CITY OF ALBUQUERQUE

May 13, 2013

Re: Inland Kenworth, Fortuna Road, Drainage Report and Conceptual Grading and Drainage Plan

Engineer's Stamp 4-23-13 (J10D044)

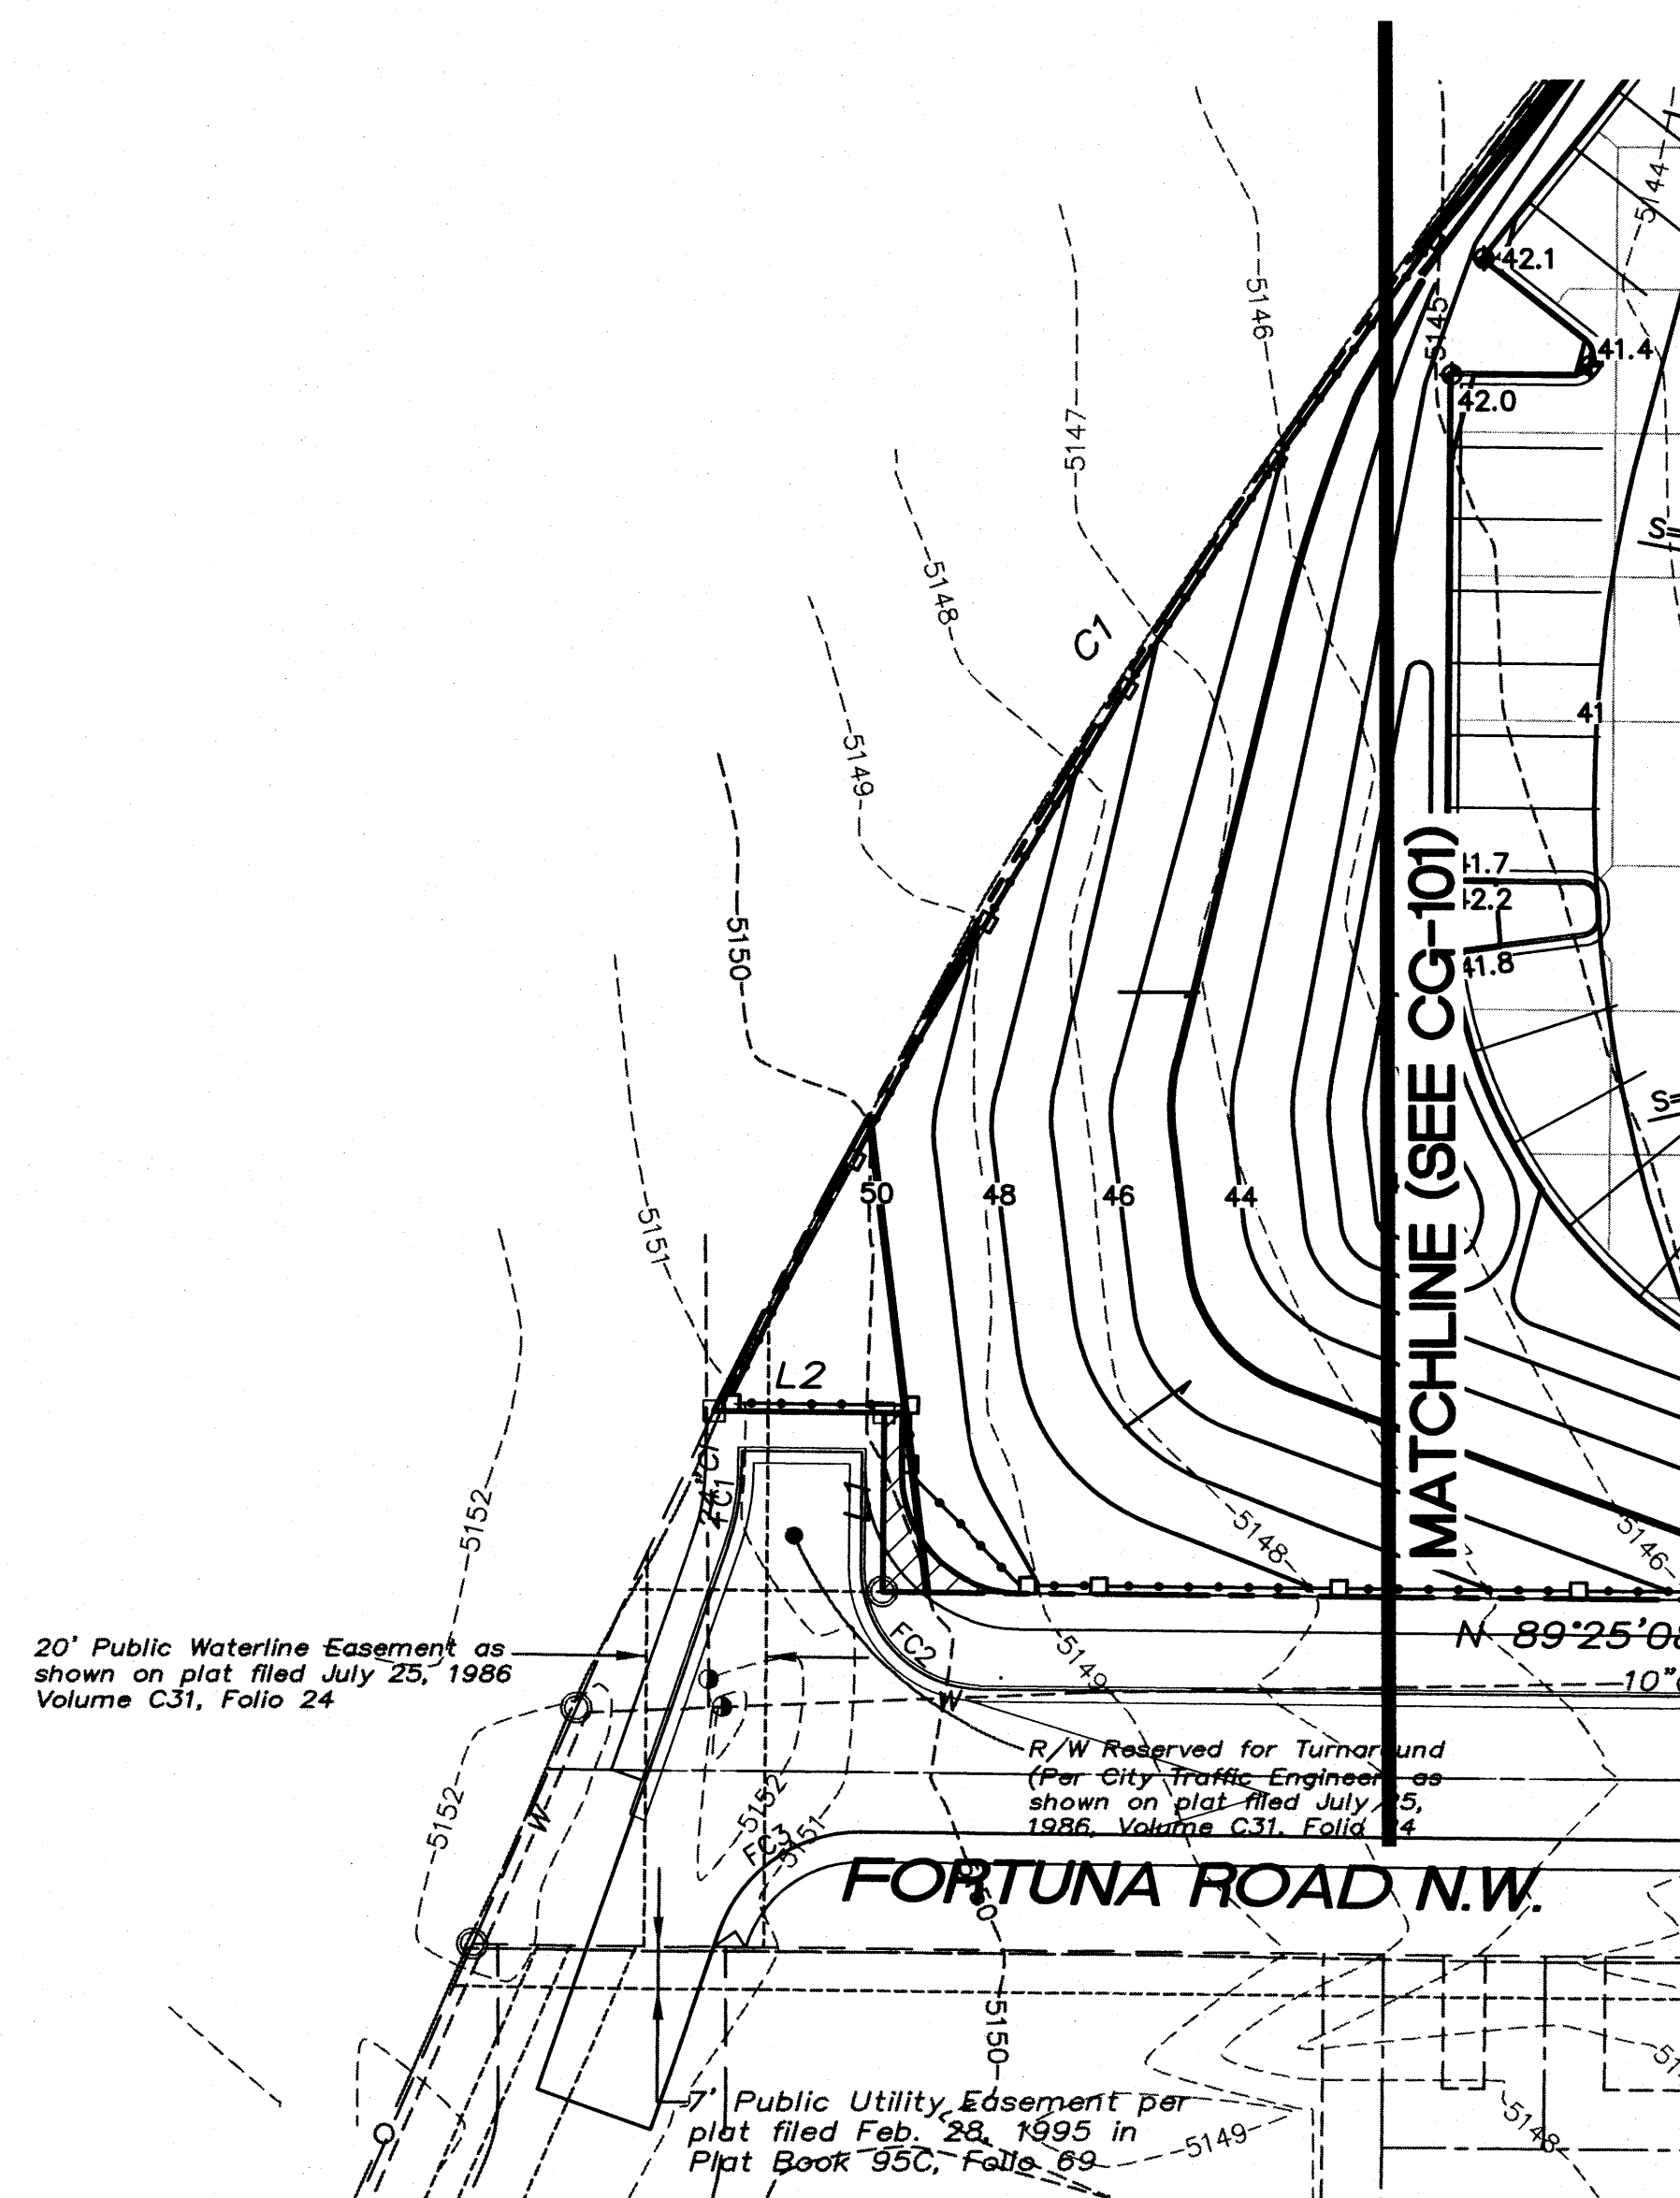
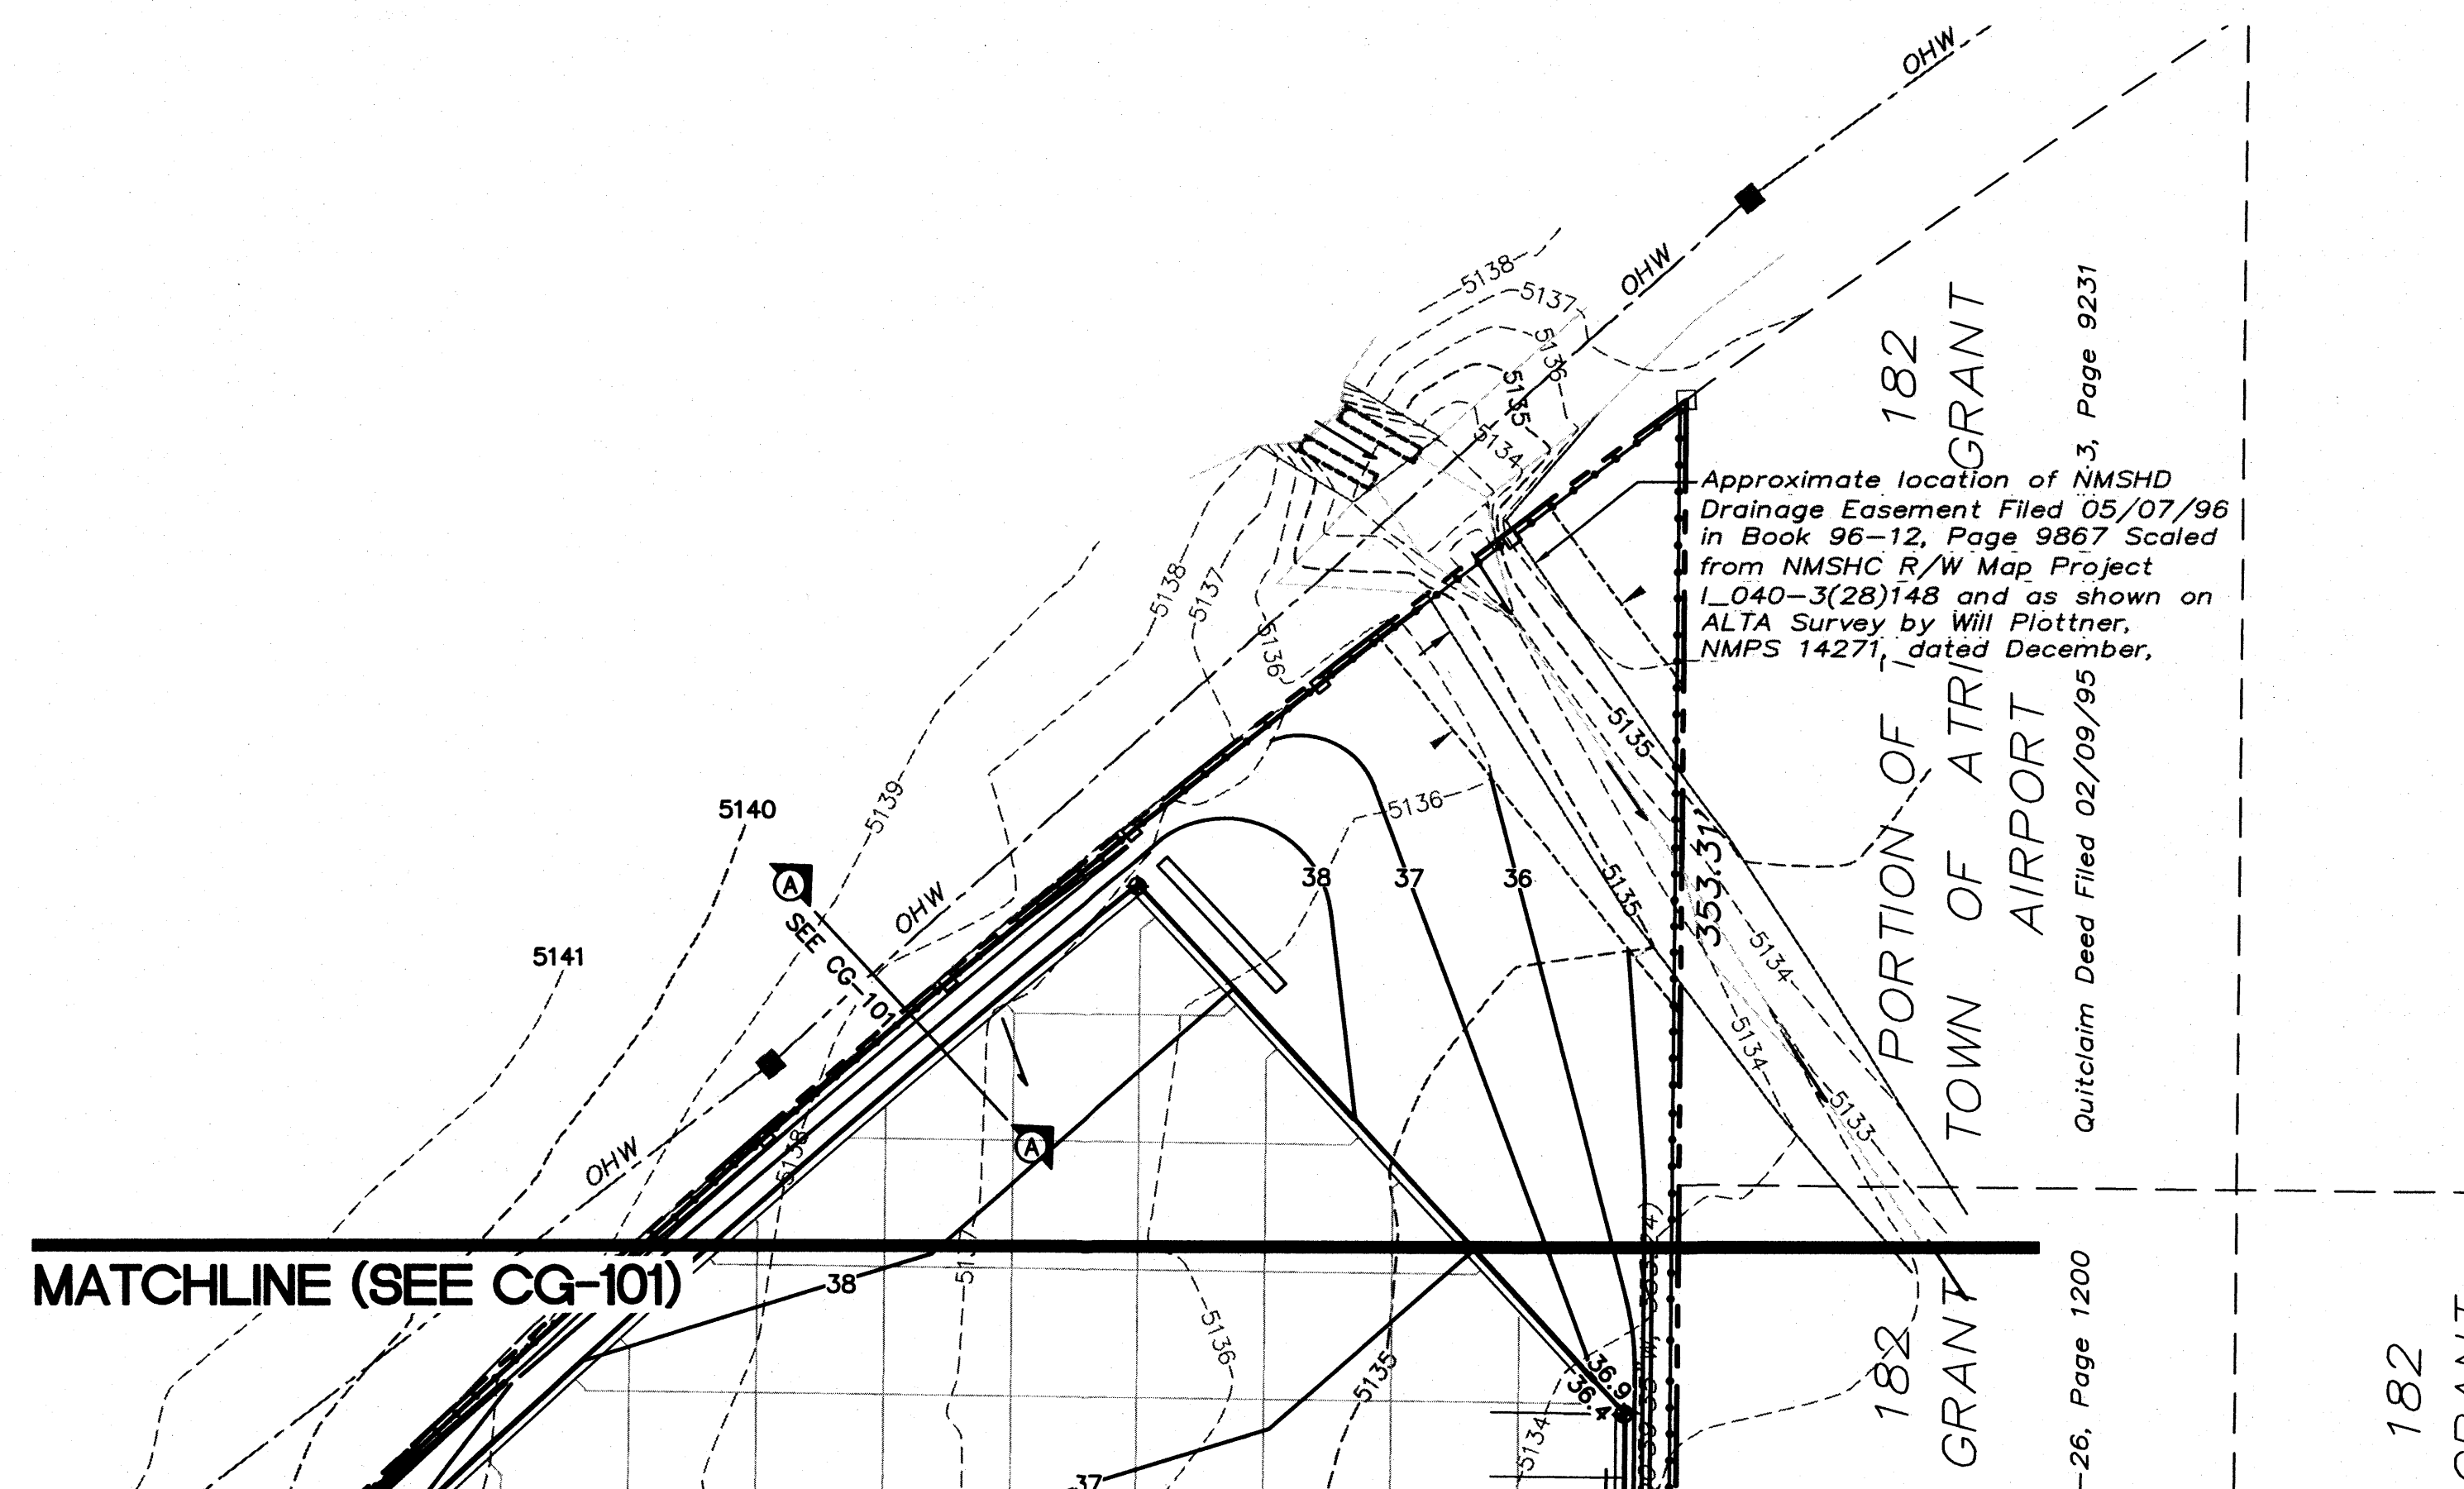
1. Per the DPM, p. 22-106, where the peak flow in the proposed lateral exceeds 10 percent of the main line, the angle of confluence should not exceed 30 degrees. This can be worked out at DRC.
2. Provide calculations for the "D" inlets assuming a 50% clogging factor.
3. Flows from Basin 2 may have difficulty turning 90 degrees as they enter the channel at the northern end. Improving this entry point should help maintain flow in the channel.
4. Provide calculations to support the sizing of the channel draining Basin 2.
